CITY OF ALBUQUERQUE

Re: No Bull Market – Site Canopy
1208 Griegos Road NW
Traffic Circulation Layout
Architect's Stamp 06-04-20 (F14-D025)

Sheet No.  
**AS101**

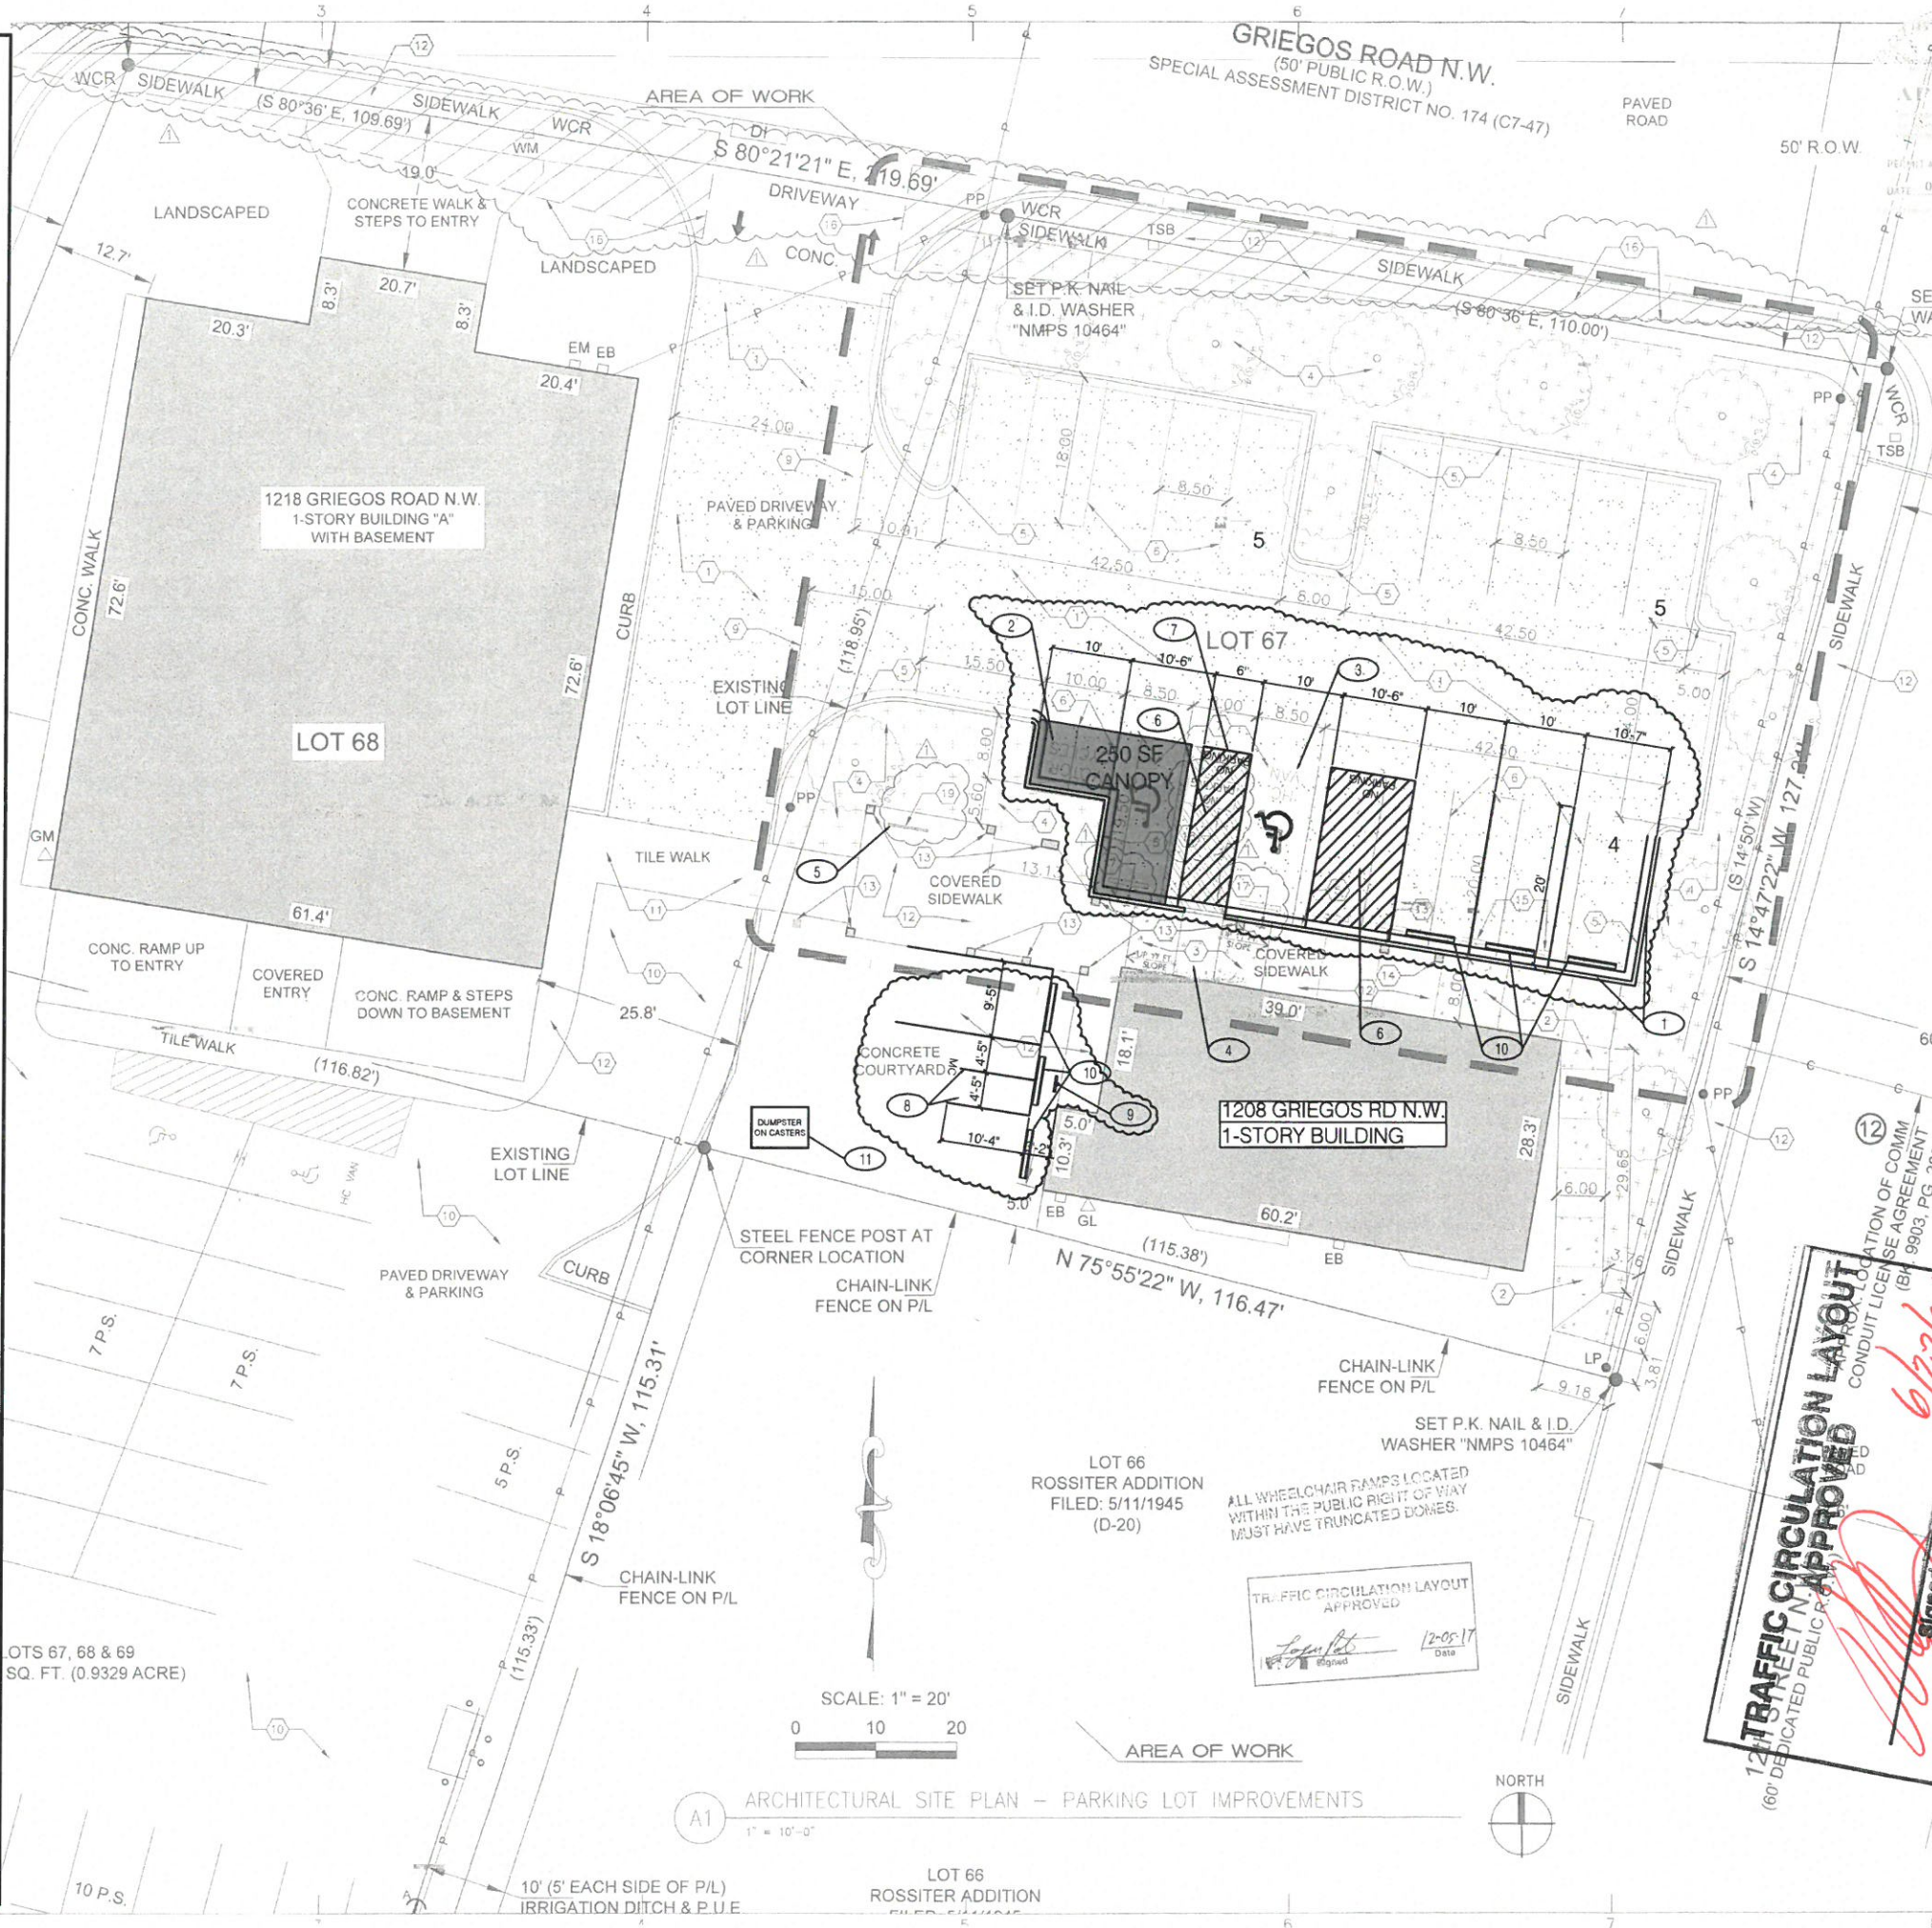
1. Please coordinate all calculations for parking spaces, including bicycle and motor cycle parking with Zoning and list the number required. Please verify.
2. Please identify all existing buildings, doors, structures, sidewalks, curbs, drive pads, wall and anything that influences the parking and circulation on the site.
3. Identify all existing access easements and rights of way width dimensions.
4. Maximum access width for **arterial**, collector, and local streets are as follows:

5. Please list the width and length for all existing and proposed parking spaces. Some dimensions are not shown.
6. The minimum parking stall dimensions are (lengths are not shown on site plans:

7. ADA curb ramps must be updated to current standards and have truncated domes installed within public frontage of Griegos Road and 12th Street.
8. Keyed Note 11: Label pavement **MC**.

9. Keyed Notes: Provide all detail sheets that are referenced on these keyed notes as well as the Architectural Drawings referenced on no. 12.
10. All bicycle racks shall be designed according to the following guidelines(**Current/updated requirements need to be met**):

14. Show all drive aisle widths and radii. Some dimensions are not shown.
15. The minimum drive aisle dimensions are shown below

16. List radii for all curves shown; for passenger vehicles. Radius for **delivery trucks, fire trucks, etc. is 25 ft. or larger.**
17. The keyway as dead-end parking aisle needs to be dimensioned.

18. Per the IDO, a 6 ft. wide ADA accessible pedestrian pathway is required from the public sidewalk to the building entrances. Please clearly show this pathway, provide details, and dimension pathway.

19. Per DPM, a 6 ft. wide ADA accessible pedestrian pathway is required from the ADA parking stall access aisles to the building entrances. Please clearly show this pathway and provide details. Shown/provide ADA ramps coming from parking stall (**8 ft access aisle**) to entrance.

20. All sidewalks along streets should be placed at the property line and not on private property as shown on Griegos frontage as well as the portion of the ADA ramp at corner of Griegos and 12th St.

21. STATUS of Refuse container/enclosure? Provide a copy of refuse approval.
22. Please provide a sight distance exhibit
23. Show the clear sight triangle and add the following note to the plan:
"Landscaping and signage will not interfere with clear sight requirements. Therefore, signs, walls, trees, and shrubbery between 3 and 8 feet tall (as measured from the gutter pan) will not be acceptable in the clear sight triangle."

**1 BIKE RACK DETAIL**  
1/2" = 1'-0"

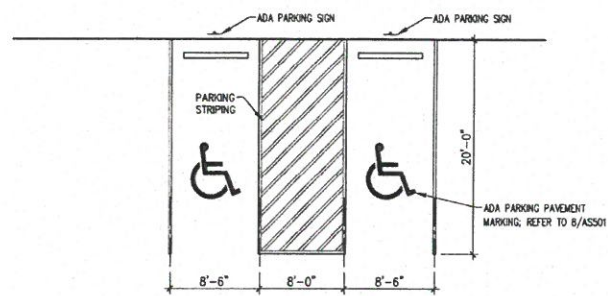
- a. The rack shall be a minimum 30 inches tall and 18 inches wide.
 - b. The bicycle frame shall be supported horizontally at two or more places. Comb/toaster racks are not allowed.

- c. The rack shall be designed to support the bicycle in an upright position. See the IDO for additional information.
 - d. The rack allows varying bicycle frame sizes and styles to be attached.

- e. The user is not required to lift the bicycle onto the bicycle rack.
 - f. Each bicycle parking space is accessible without moving another bicycle.

11. Bicycle racks shall be sturdy and anchored to a concrete pad.
12. A 1-foot clear zone around the bicycle parking stall shall be provided.
13. Bicycle parking spaces shall be at least 6 feet long and 2 feet wide.
